Mr Peter Walker
Grosvenor Gardens
32
Bognor Regis
PO21 3EZ

Please ask for: Sian Eggington
Email: sian.eggington@terraquest.co.uk
Telephone: 0121 2341390
Our Ref: BR/198/20/HH
Your Ref:
Date: 27th August 2020

Application for Planning Permission for Works or Extension to a Dwelling

Development: extend drop kerb by 2.3 meters
Location: 32 Grosvenor Gardens Aldwick PO21 3EZ

Plan Reference Number: TORCM20237096121436

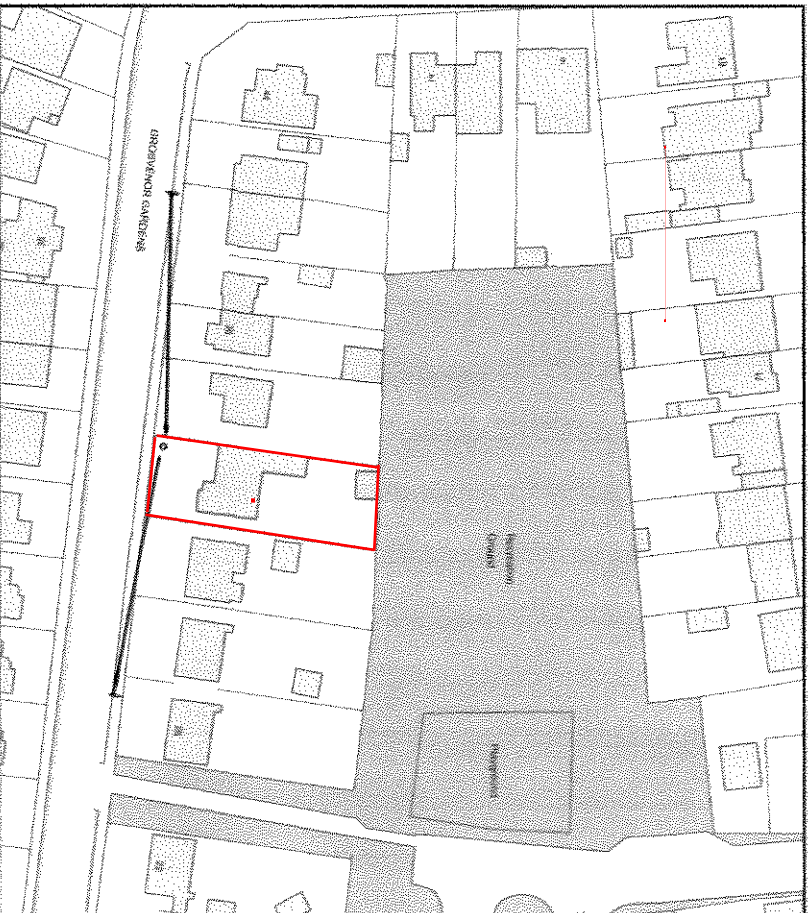
Location Plan: You are required to include a red outline on the location plan outlining the proposed site.
